From: Graham Evans
Sent: 06 July 2012 11:18
To: Planningecons
Subject: Planning Consultation on EG/43/12/
Attachments: Biomass_Boiler_Information_Request_Template.doc; Biomass_Developers_Leaflet.pdf
 EH comment as follows:

APPLICATION EG/43/12/
NO:

Registered: 21-JUN-12
Site Eastergate C of E Primary School Church Lane Eastergate
Address: PO20 3UT

Category: West Sussex Cons
Description of Works: Application under Regulation 3 of the Town & Country Planning General Regulations 1992 for a proposed containerised biomass boiler (this application will be determined by West Sussex County Council)

DOUCH ECO 1 SRINGHILL ORCHARD, WEIRWOOD, FOREST ROW, EAST SUSSEX, RH18 5HT. 01342 825143
DRAWING NUMBER: 0029 010
DRAWN BY: AK
DATE: 04/04/2012
SCALE: 1:50 @ A3
CLIENT: JUDE HOLLAND
ADDRESS: EASTERGATE PRIMARY SCHOOL
TITLE: BOILER SECTION A A
REVISION: 1
NOTES:

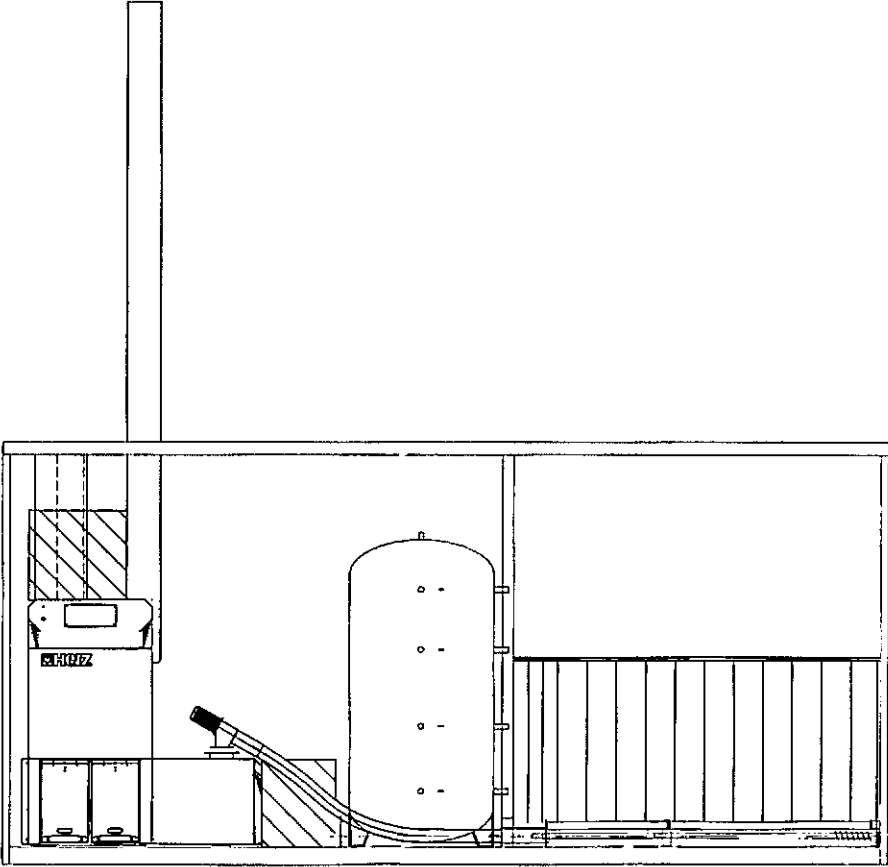
Such furnaces also require approval from this authority in respect of the proposed chimney height, which cannot be readily ascertained from the submitted details. We are unable to approve a proposed chimney height unless we are satisfied that it will be sufficient to prevent emissions becoming prejudicial to health or a nuisance. The stack height must therefore be identified and evidence presented to demonstrate that predicted emissions associated with the calculated stack height will not unreasonably impact upon the area. Dispersion modelling may be required to ascertain an appropriate stack height.

DOUCH ECO
1 SRINGHILL ORCHARD, WEIRWOOD, FOREST ROW, EAST SUSSEX, RH18 5HT. 01342 825143
DRAWING NUMBER: 0029 011
DRAWN BY: AK
DATE: 04/04/2012
SCALE: 1:50 @ A3
CLIENT: JUDE HOLLAND
ADDRESS: EASTERGATE PRIMARY SCHOOL
TITLE: BOILER PLAN
REVISION: 1
NOTES:

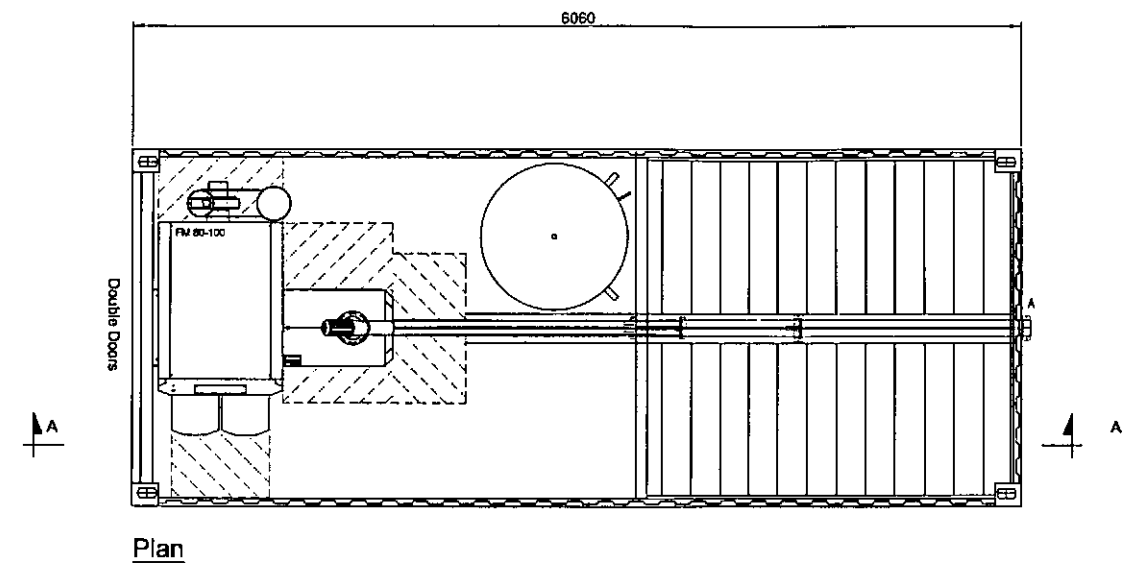
The application proposes the use of pelletised fuel which will have consistent size, geometry and moisture content (a condition might be considered in respect of fuel specification), no detail is provided in respect of fuel storage.
